From: Simon Davis
Sent: 19 June 2013 17:19
To: 'Richard Ostler'
Subject: RE: Trees affected by AW/91/13

Front boundary wall and gates
22 The Drive Aldwick

Development Front boundary wall and gates.

Location 22 The Drive Aldwick,,

PLAN NO 630|3

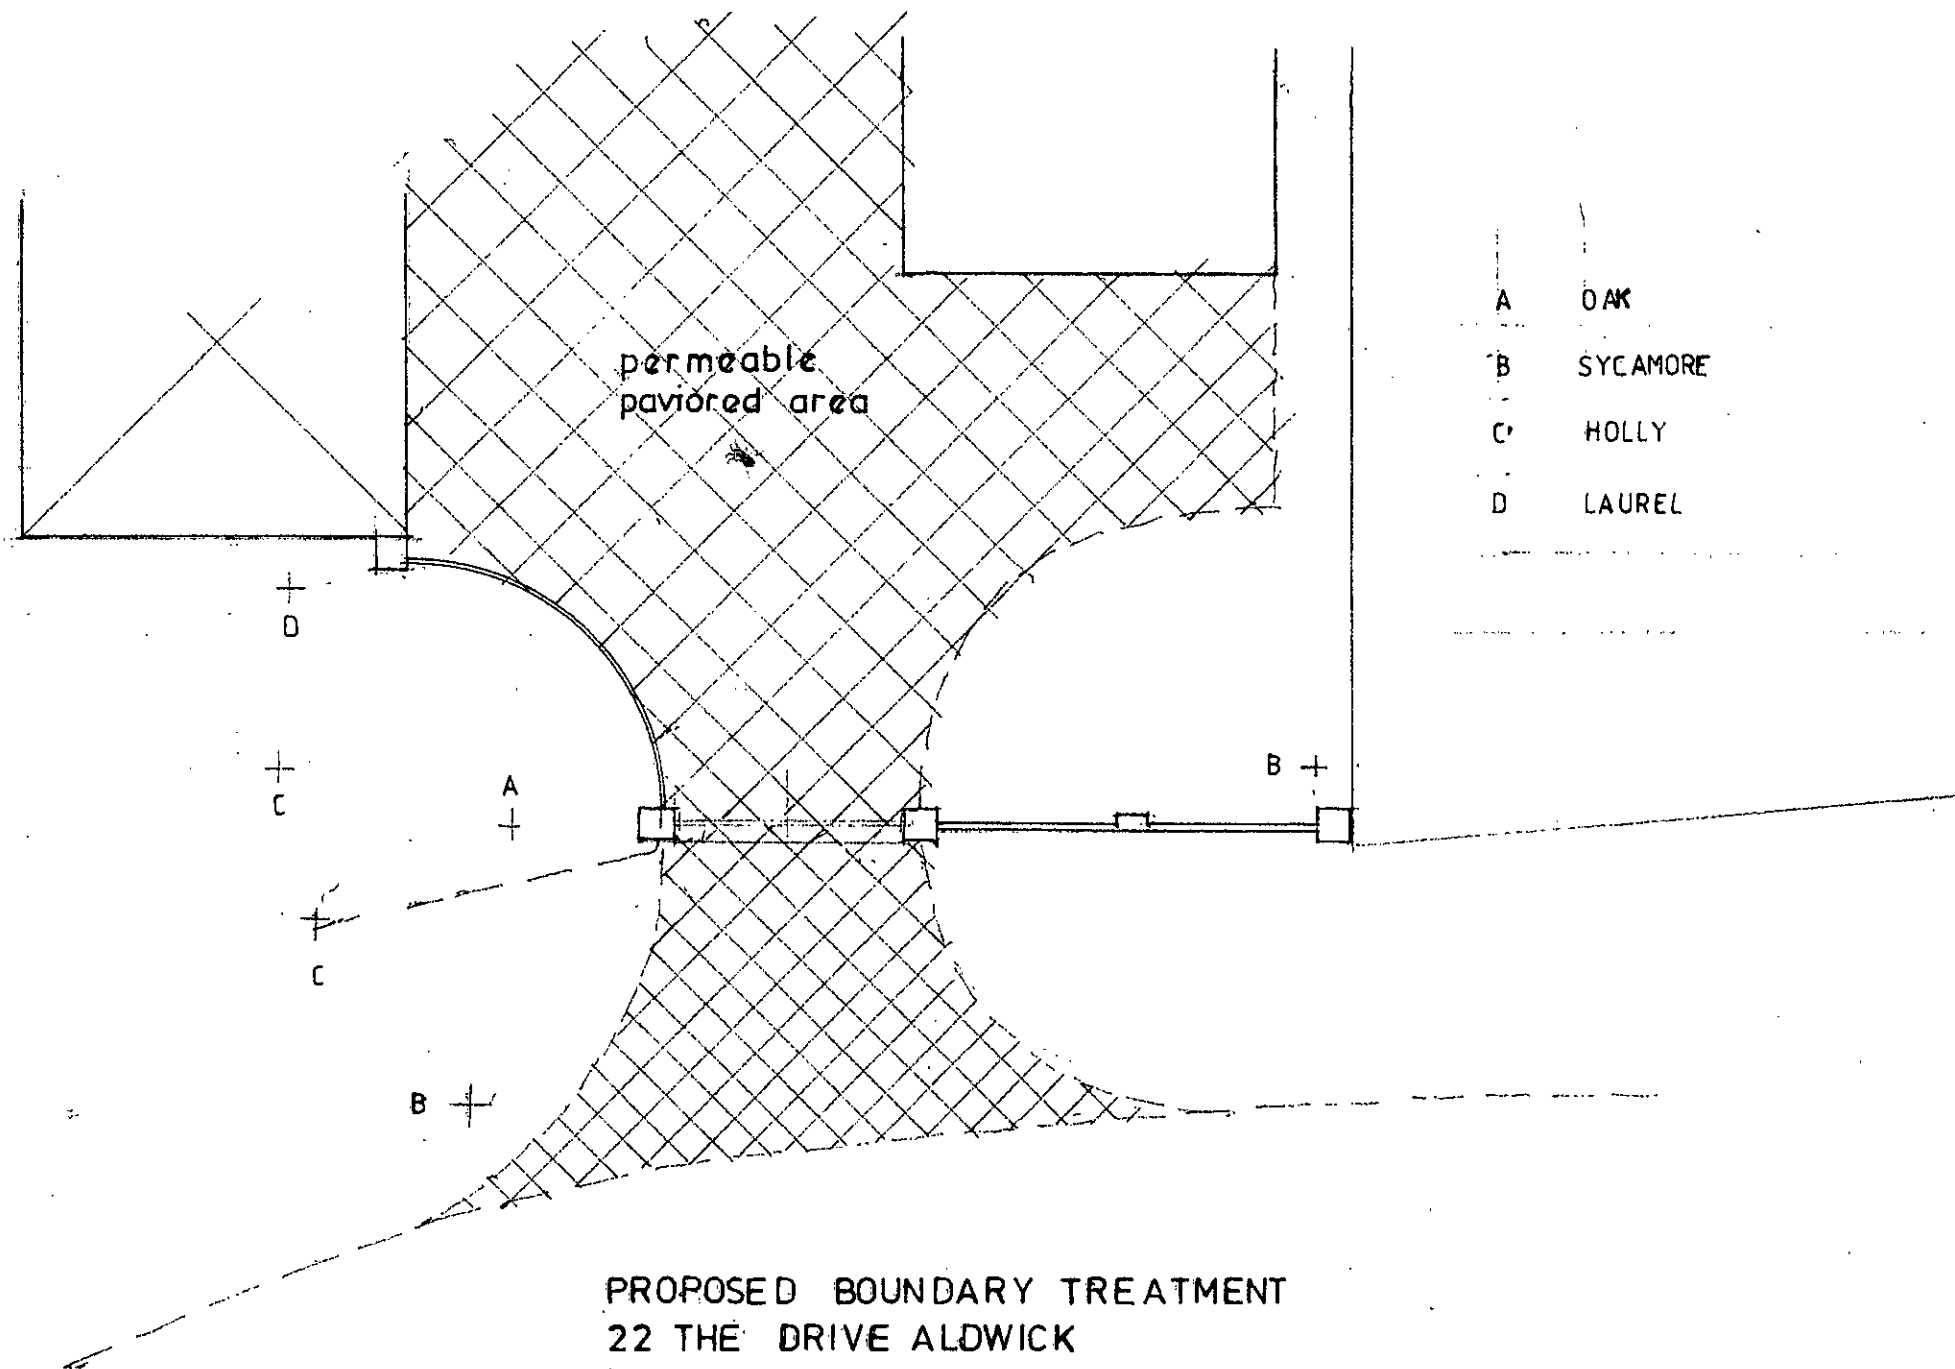
I am aware that block paving is shown on the application and that this is a change to the existing situation (and that permission is required for this change). This new paving was not listed on the application form and I assume that either (a) the owners are not aware that permission is required or (b) that they were going to seek consent for the new wall first and then submit an application for the paviers separately.

On reflection tree roots are likely to be encountered and damaged within their root protection area (x12 diameter as measured at 1.5m of main stems) if the new surface will be built below the original depth (no details of depth has been provided) where roots have grown and established. If the driveway surface can be kept to original depths and the disturbance restricted to a 'minimum width' and depth of 600mm. It is good to hear that the applicant is willing to re-locate should significant roots be encountered. I would suggest that the foundations should not be built any closer than 1.5m of a tree stem due to the significant size differences between closer growing anchor roots when compared to lesser sized and slender feeder roots.

Also I'm going to consult you on AW/91/13 "Front boundary wall and gates" @ 22 The Drive, Aldwick. The reason being that the wall appears to cut right in front of one tree near the neighbours hedge and then cuts close to a second tree near the garage. I will also ask the agent to mark the trees on the plan and for details of foundations. Please see photos DSCN0259, 0260, 1482 & 1485.

In response to your e-mail I attach two copies of my tree survey and two copies of the same plan with the foundation detail provided by Mr Hilton.

TYPICAL SECTION.

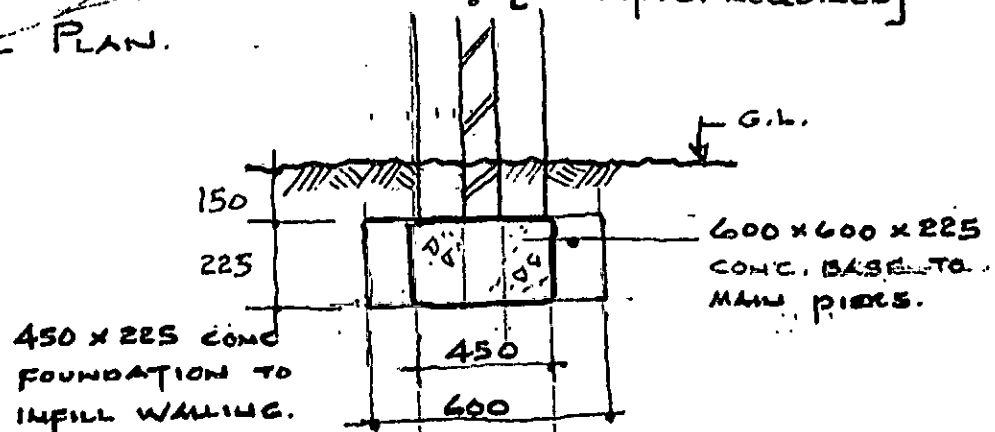
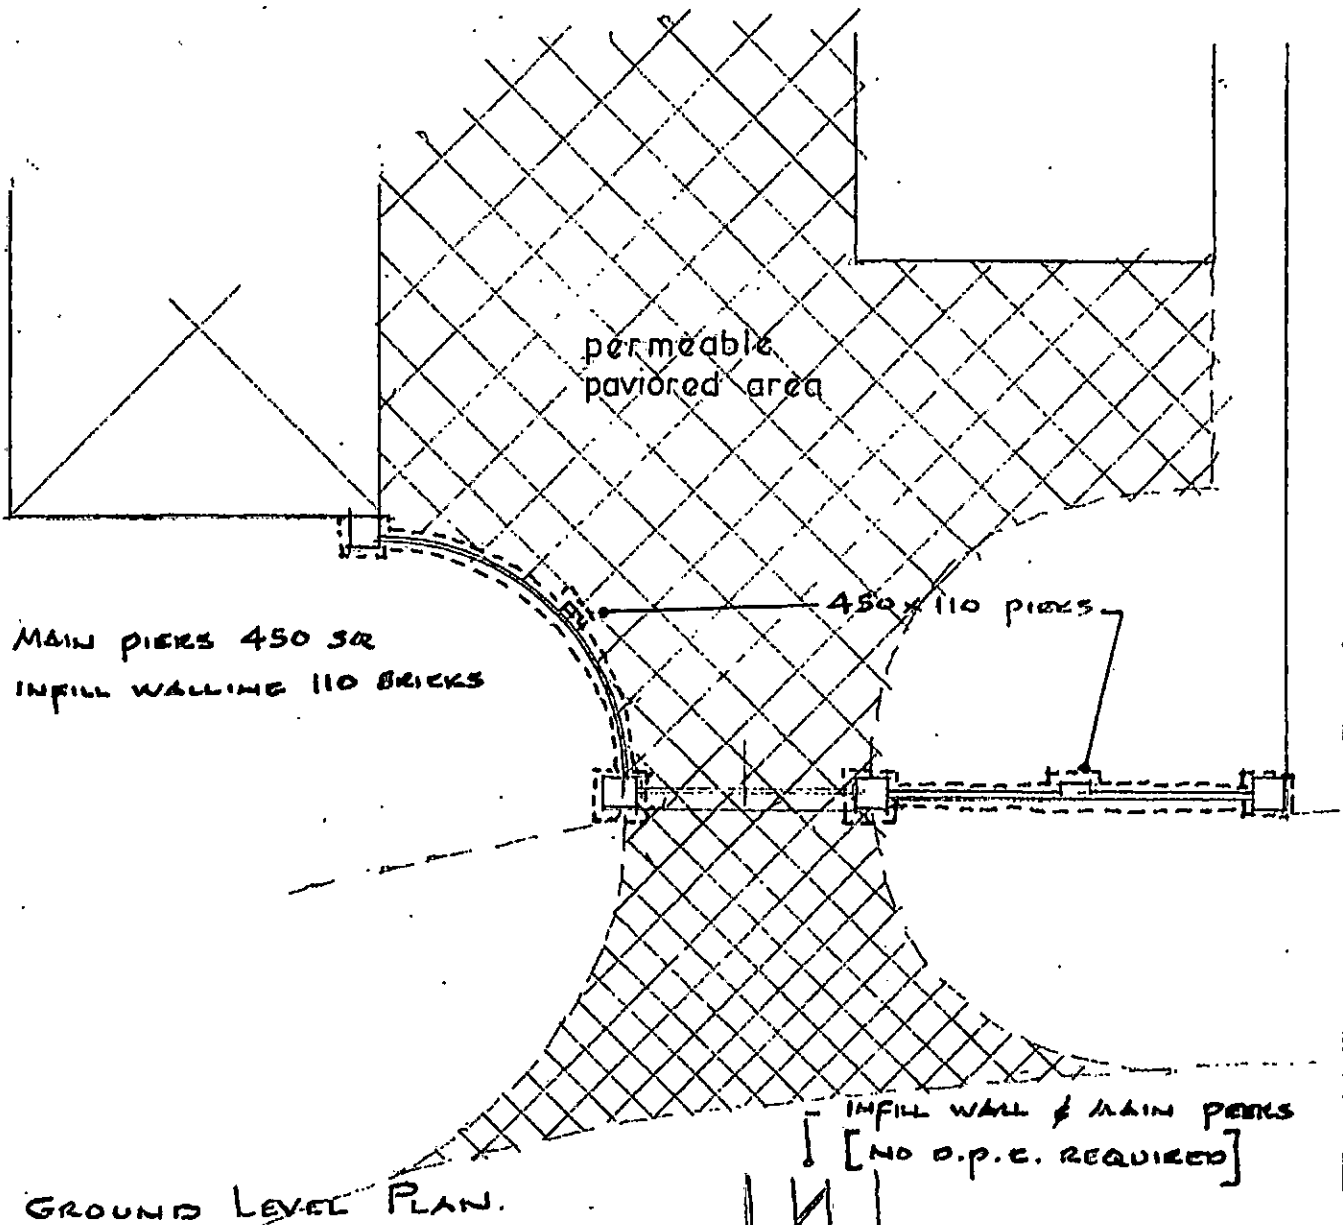
Further to my response the 450mm below ground depth foundations for the wall within the RPA would impact directly upon the tree group and therefore the application should be refused consent.

Please find attached a picture showing the three trees. One has a stem cavity. Are we concerned that these trees will be affected by the proposal. Are they worthy of retention seen as high 'visual' amenity. Apart from the 600mm foundations for the pillars how deep will the new surface be and will the removal of the old surface cause damage to underlying roots?

I would confirm tha the foundations will be hand dug and if any evidence is found of potential dramage to the trees is found either a bridging arrangement will be made or if necessary the wall will be repositioned to a suitable alternative position.
